Your Ref: OWPC26019
Our Ref: A/30/20/PL 27-02-2020
Please ask for:
David Spring

Demolition of existing building & construction of 2-bedroom bungalow with associated parking & landscaping (resubmission following A/146/19/PL). This application affects a Public Right of Way.

Land to the Rear of 1 The Heathers Arundel Road Angmering

Proposed Bungalow Plans and Elevations

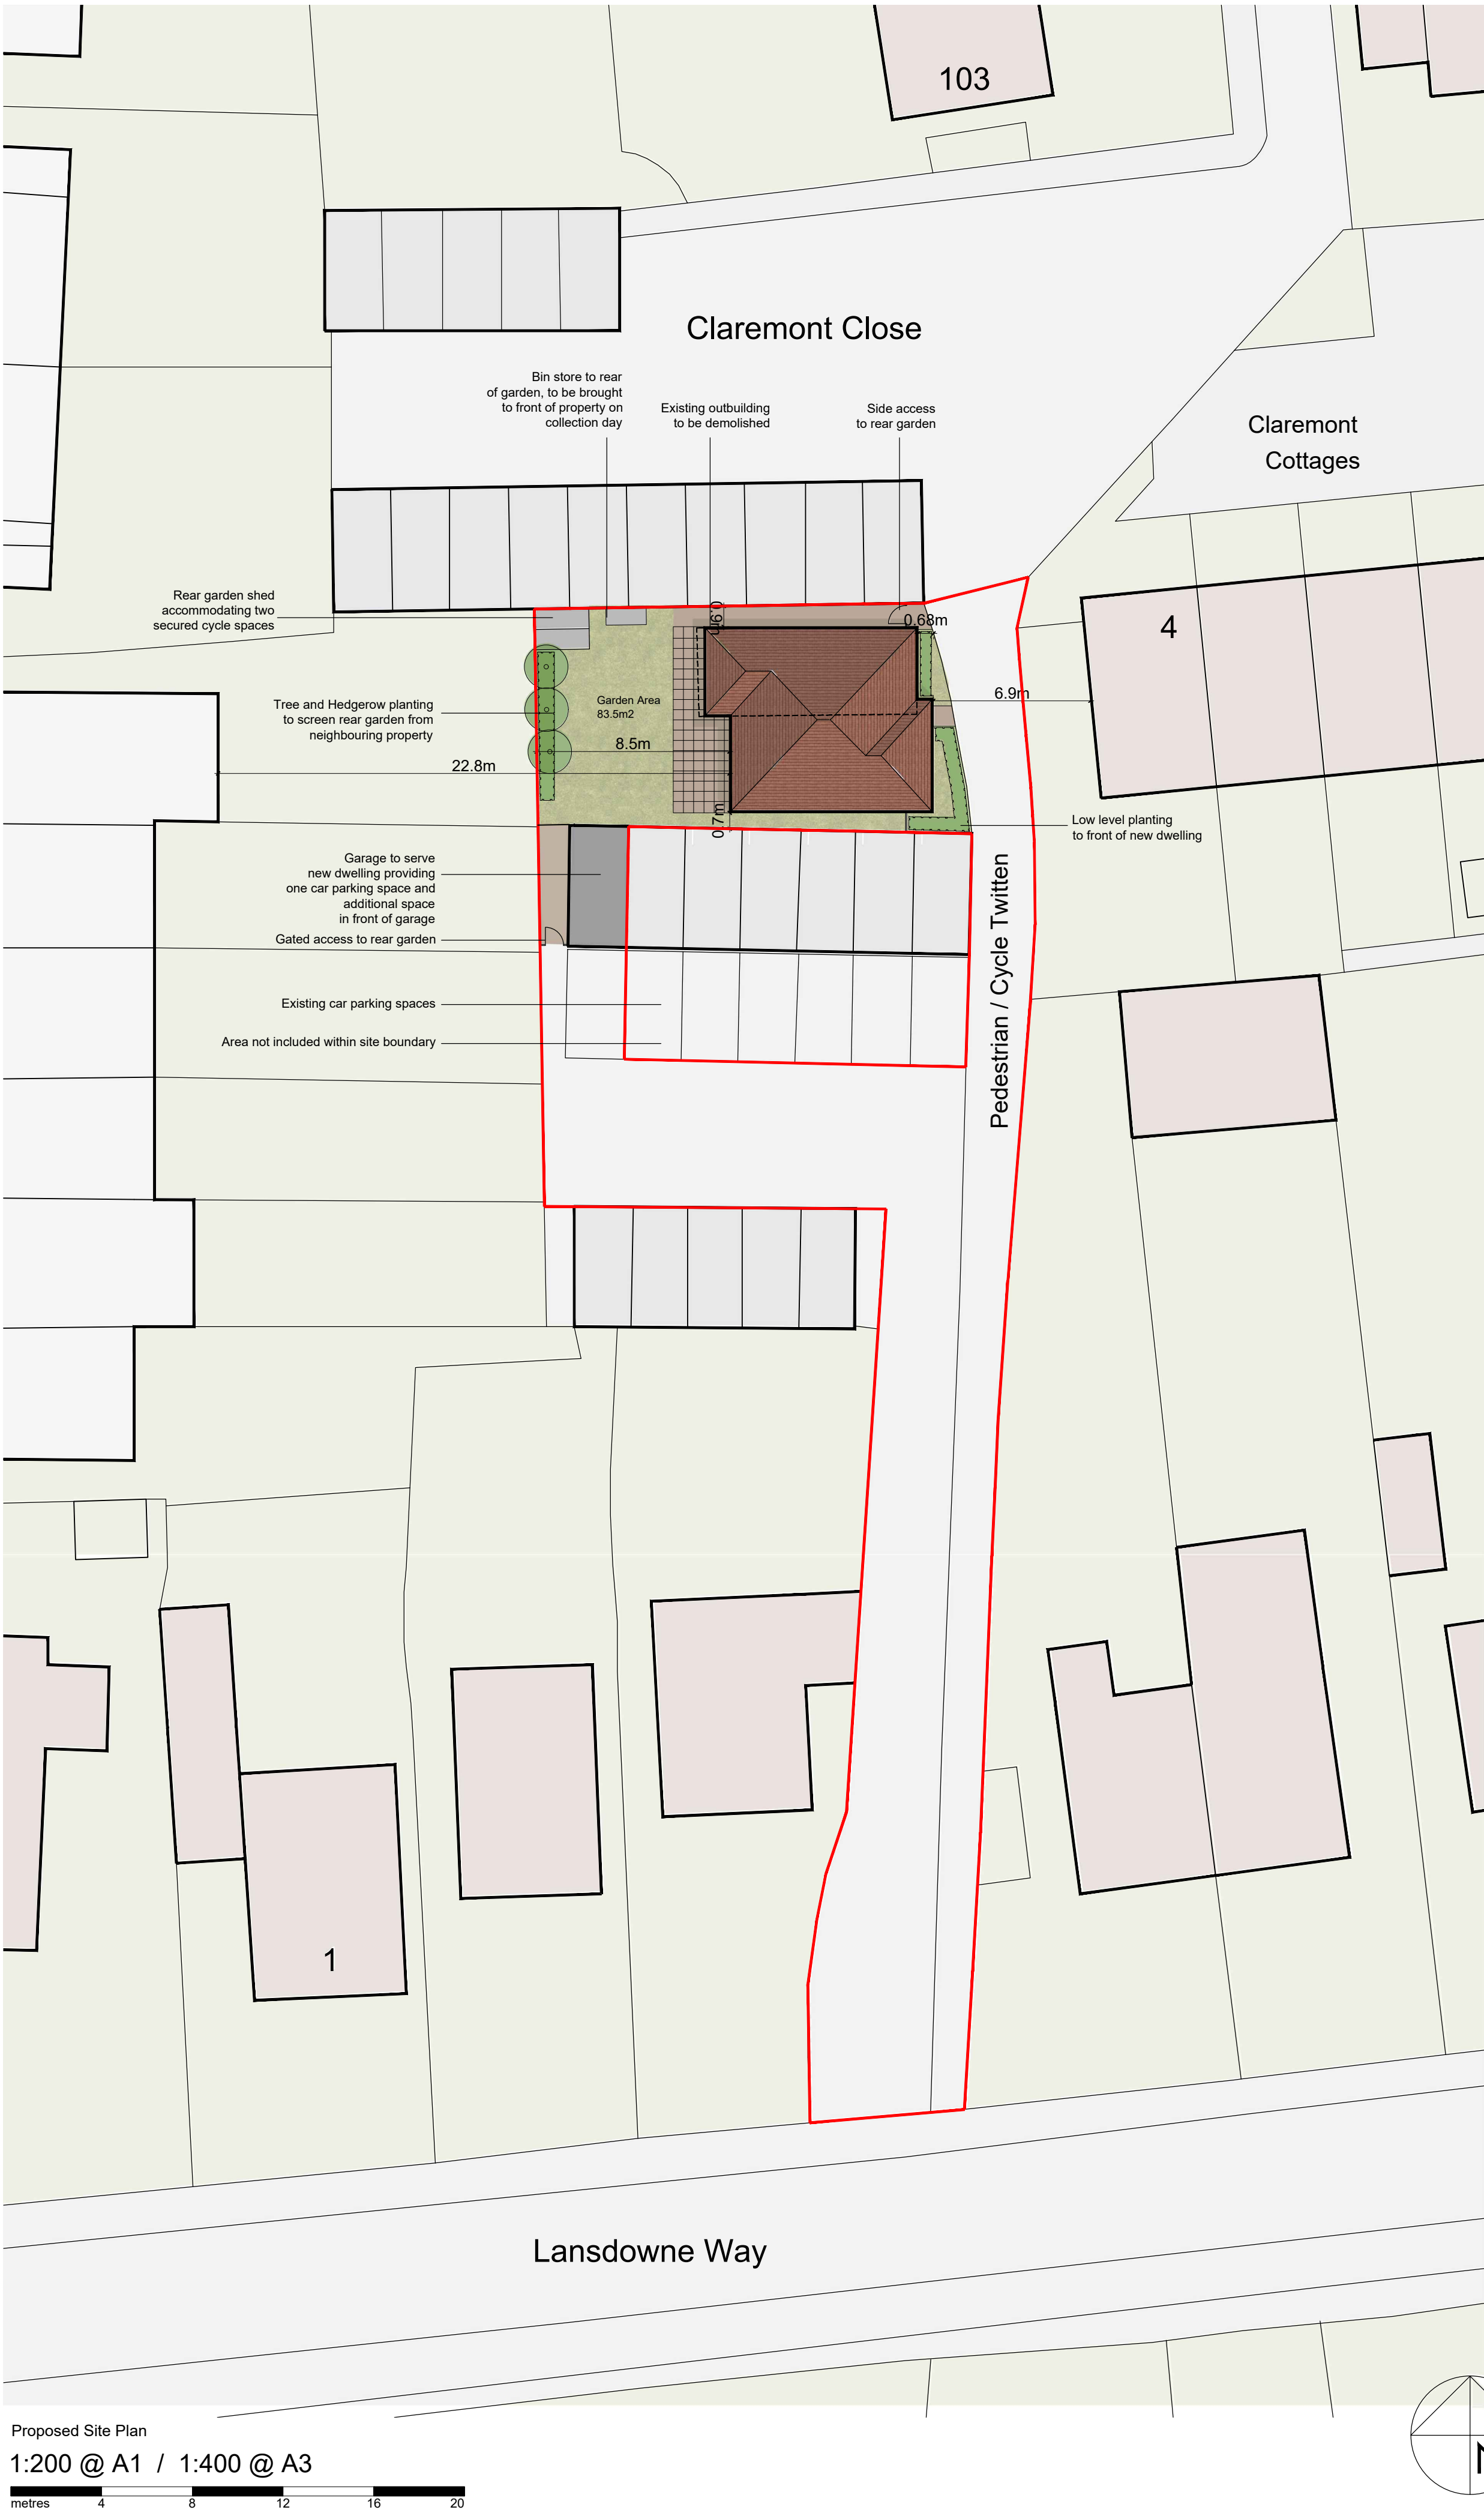
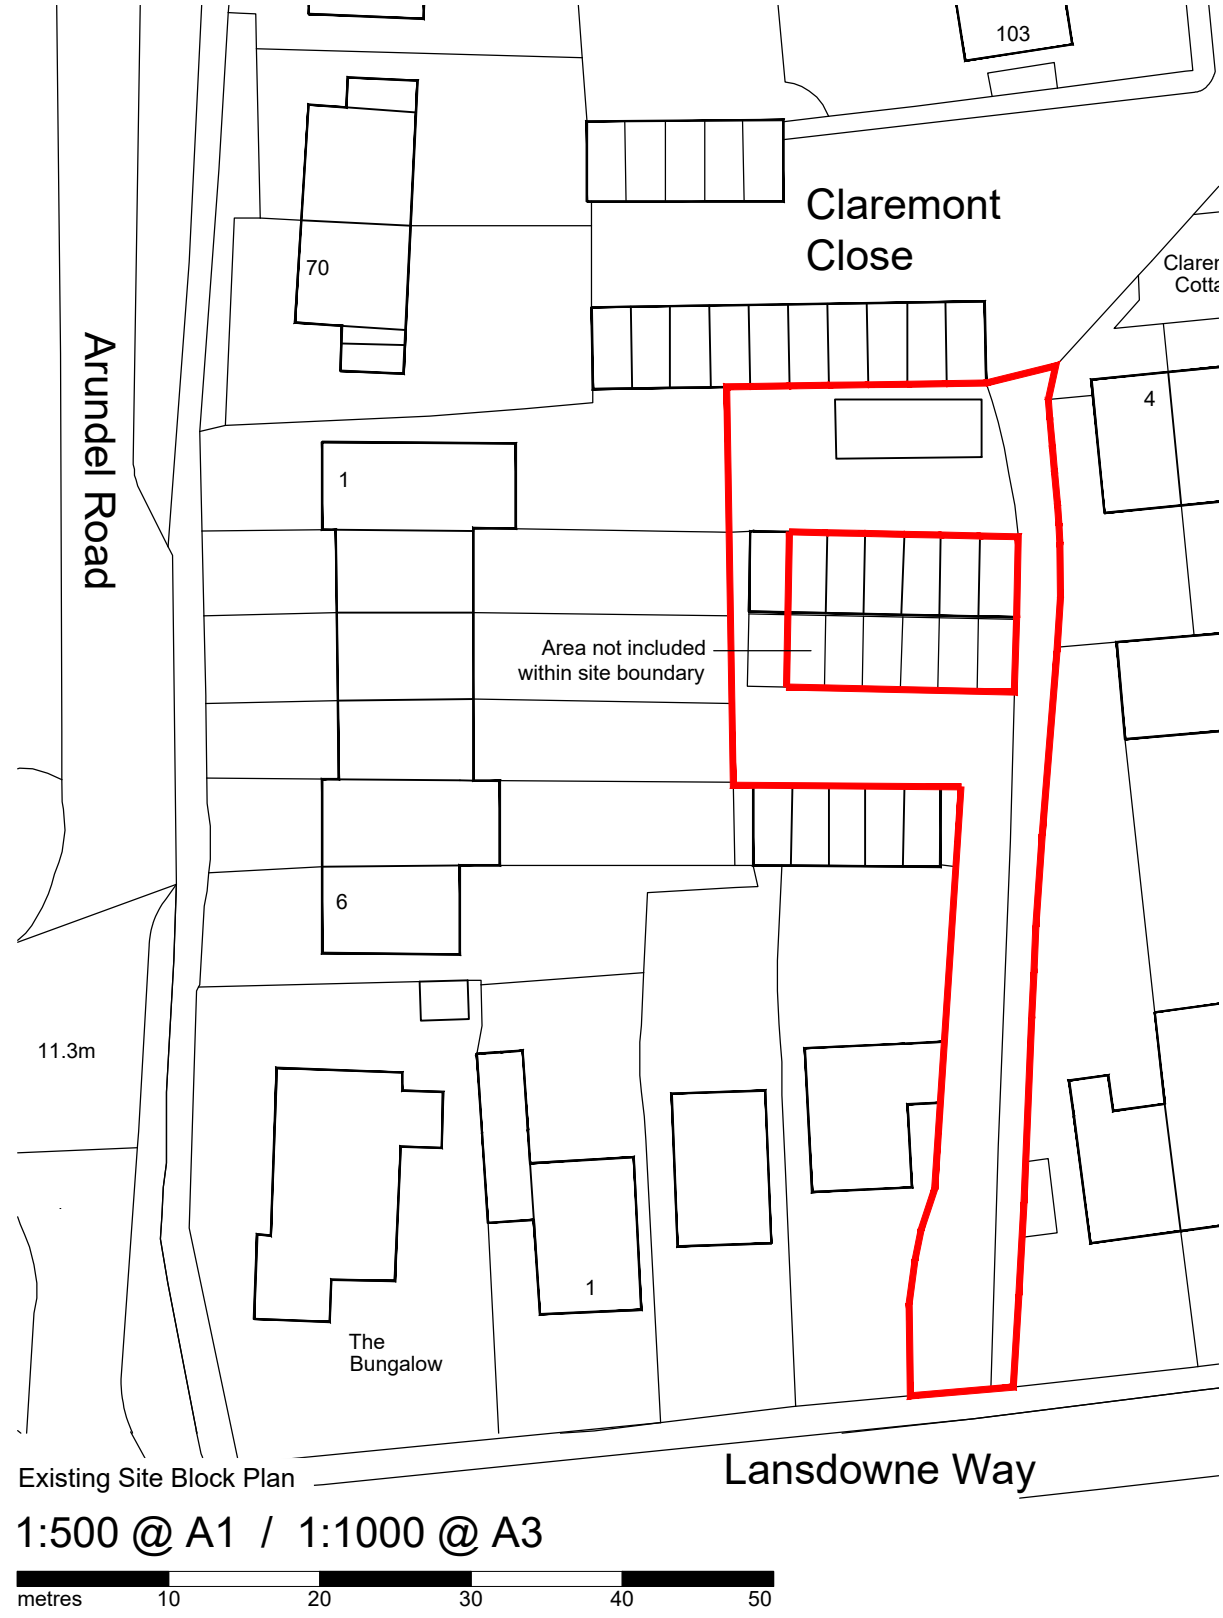
The application along with the plans implies that the applicant has a means of access to the garage site and garage.

The drawing, Proposed Bungalow Plans and Elevations, the plan shows the parking areas in front of the garages on the north side of the compound as "Area not included within the site boundary". It does not shown a similar area for the garages on the south side and the approach road to the compound.
